Re: 28 Monument Square – Code Violations

Re: Existing Conditions Walk-Thru  
28 Monument Square, Portland, Maine

Code Synopsis: 2009 IBC

28 Monument Square Basement

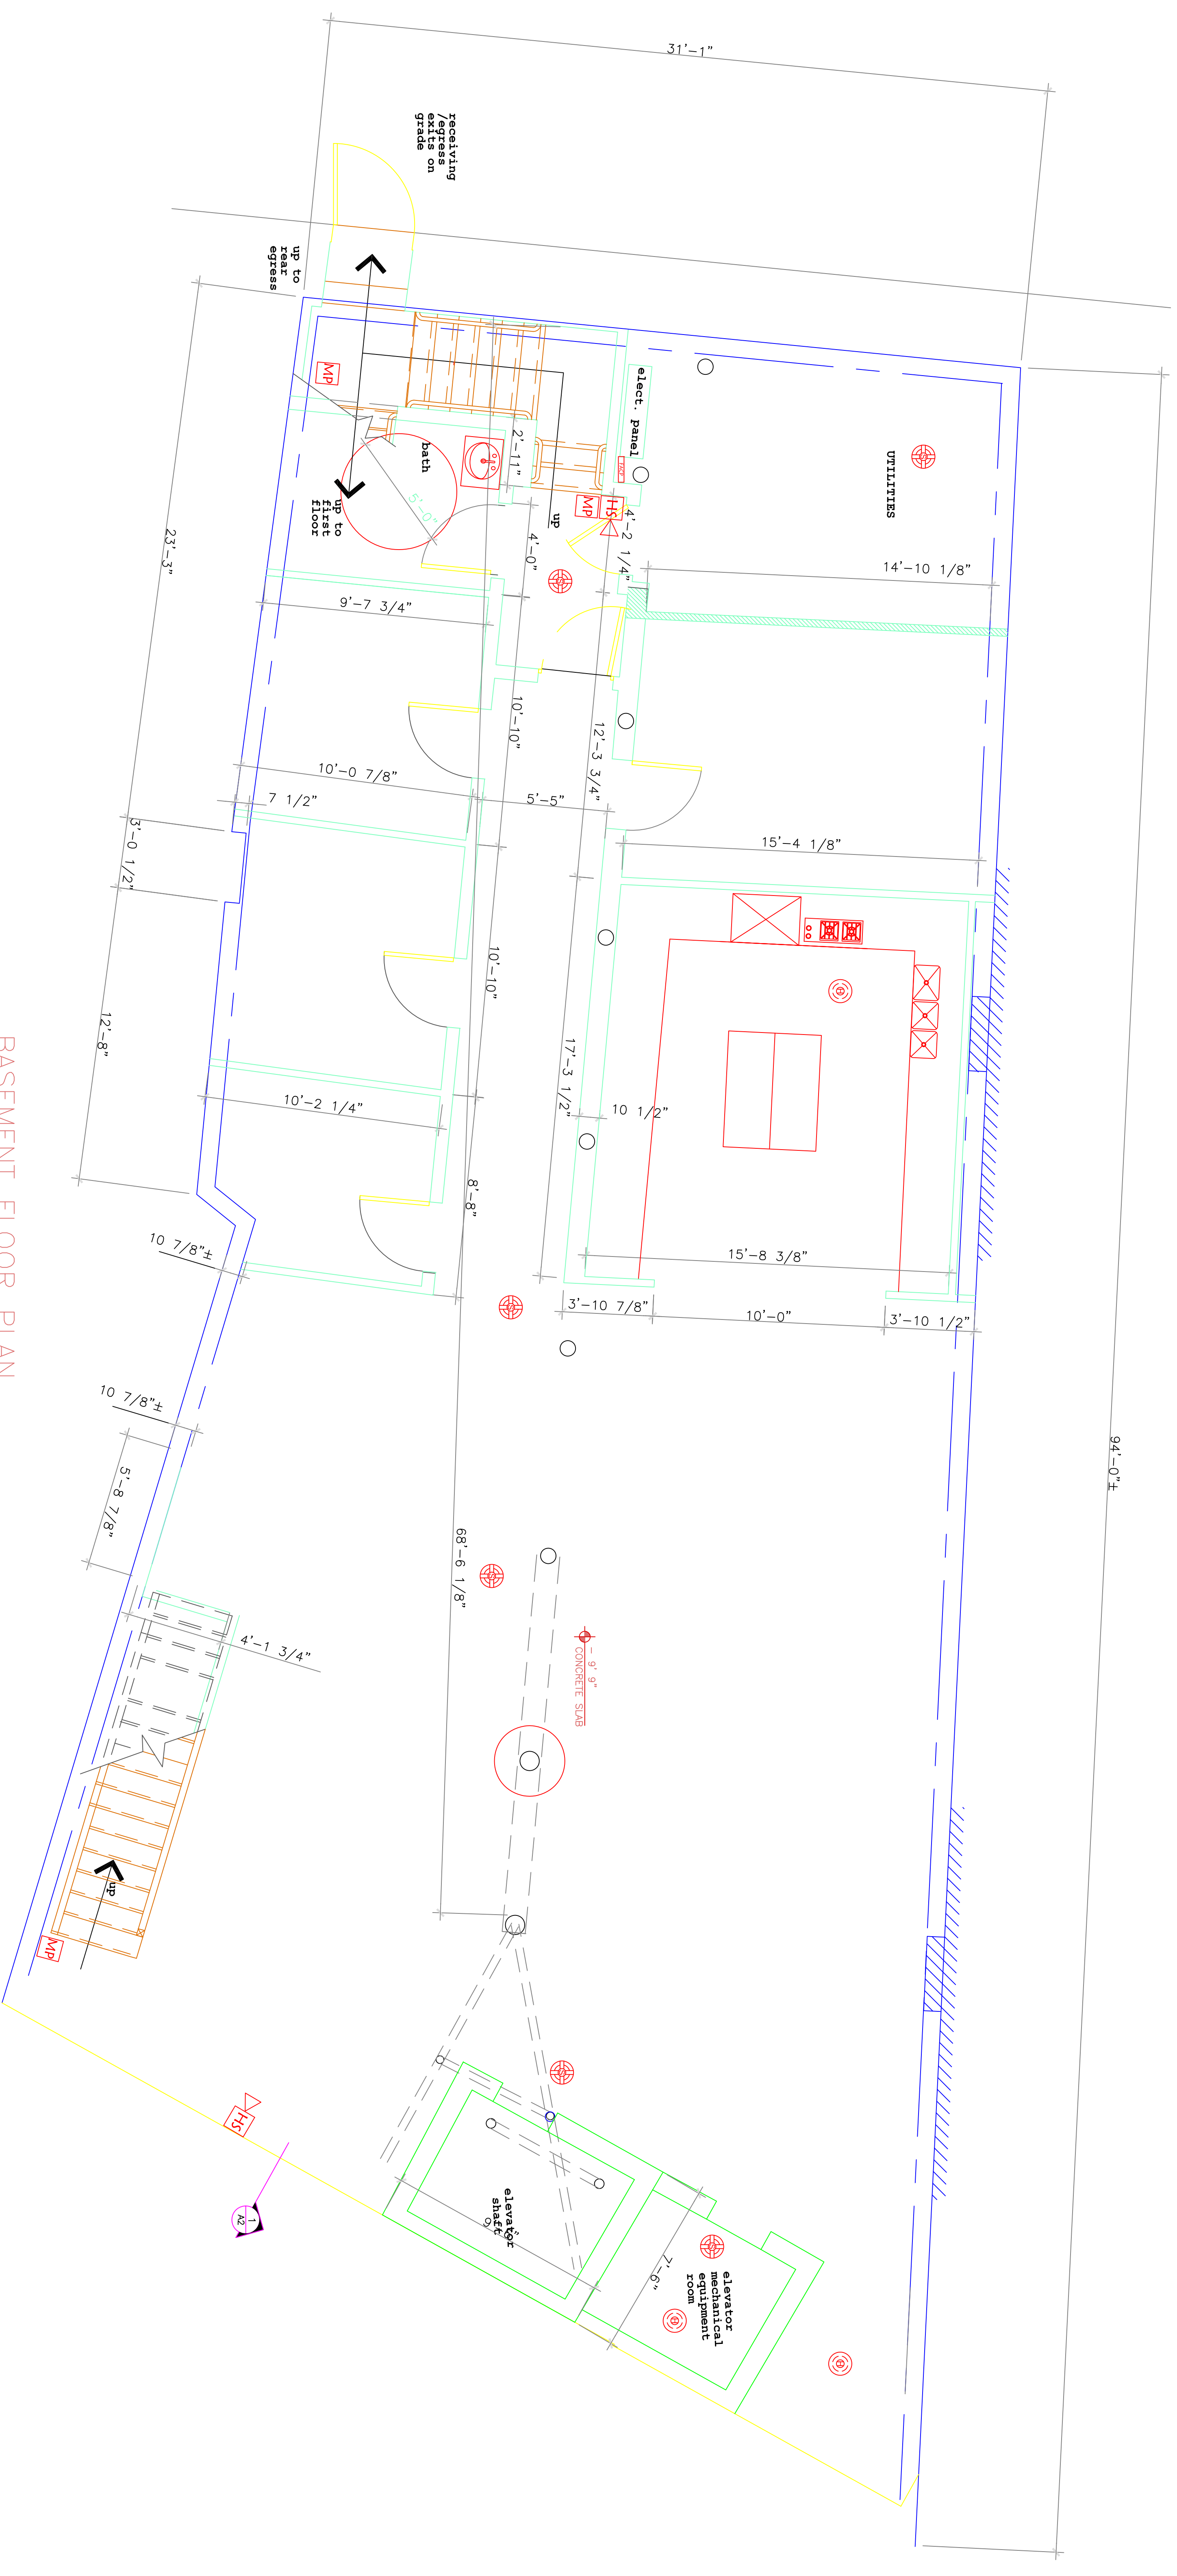
1. The posted construction permit dated 2/1/10 has expired. The work appears incomplete.
2. The existing grease trap in the commercial kitchen area appears to be connected to an excessive amount of sinks. The capacity and service schedule should be confirmed.
3. The walk-in cooler appears to have non-NFPA equipment (cooling unit) and finishes.
4. One electrical panel has electrical tape over breaker switches.
5. There is a significant void in the ceiling/floor construction assembly along the length of the west masonry wall. Additionally, there are multiple areas where pipe/conduit penetrations do not appear to be fully sealed. This may be a contributing factor to the presence cooking odors detected in the floors above.

CLIENT  
DATE  
DRAWN BY  
CHECKED BY  
DATE AUG. 08, 2008  
SHEET TITLE  
BASEMENT MECHANICAL PLAN

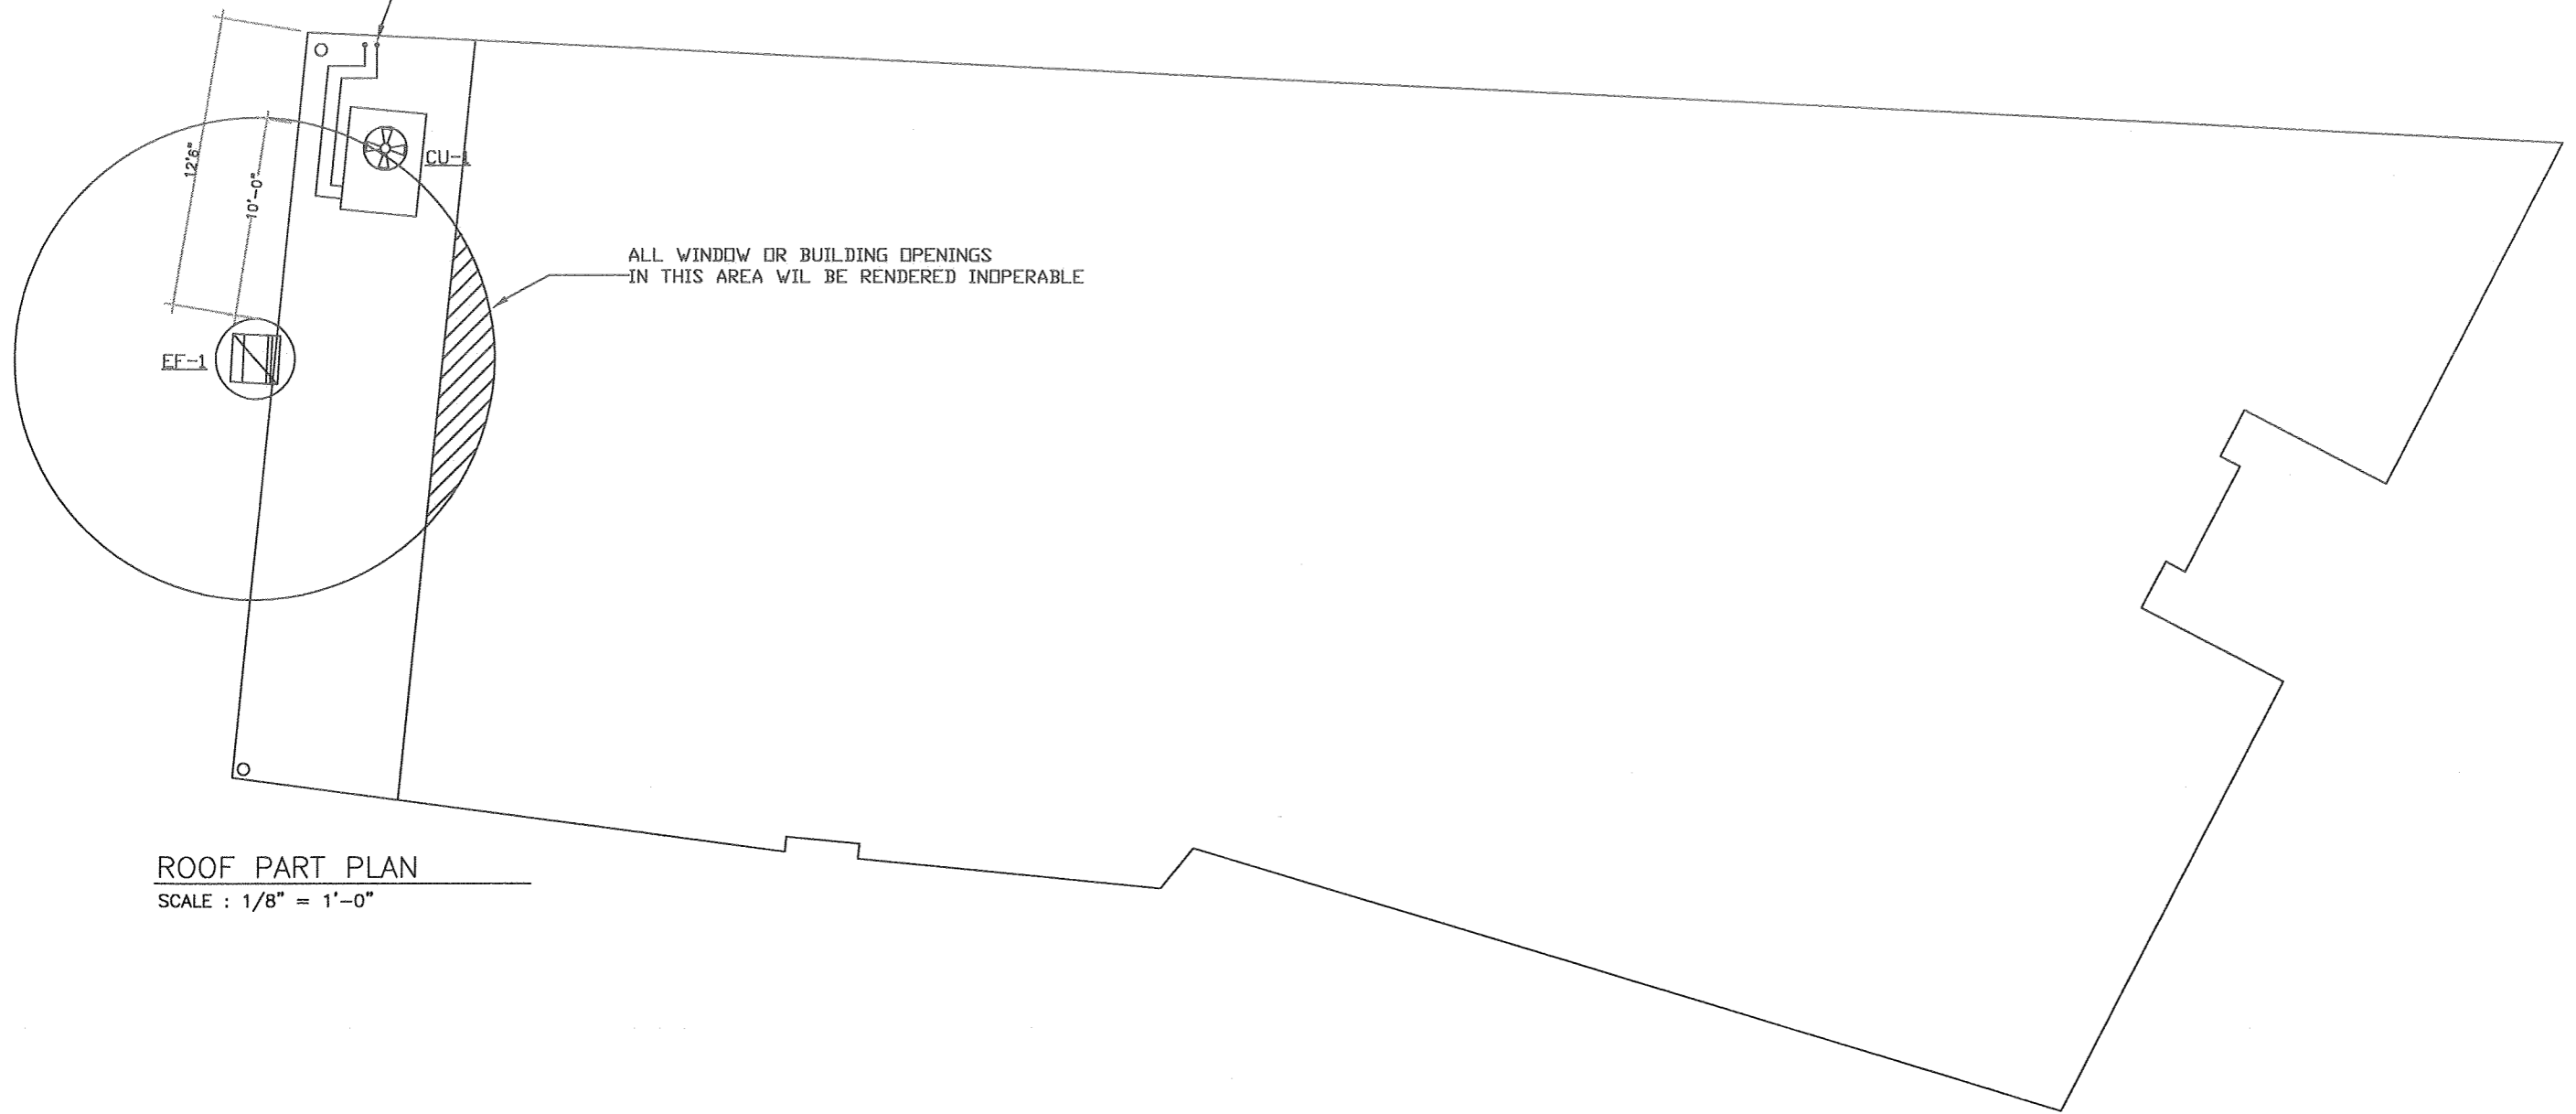
3. The basement exhaust hood exterior duct termination is less than 10' from two (2) operable double hung windows at the south wall. Code requires such exhaust to be 10' minimum clear from these openings.
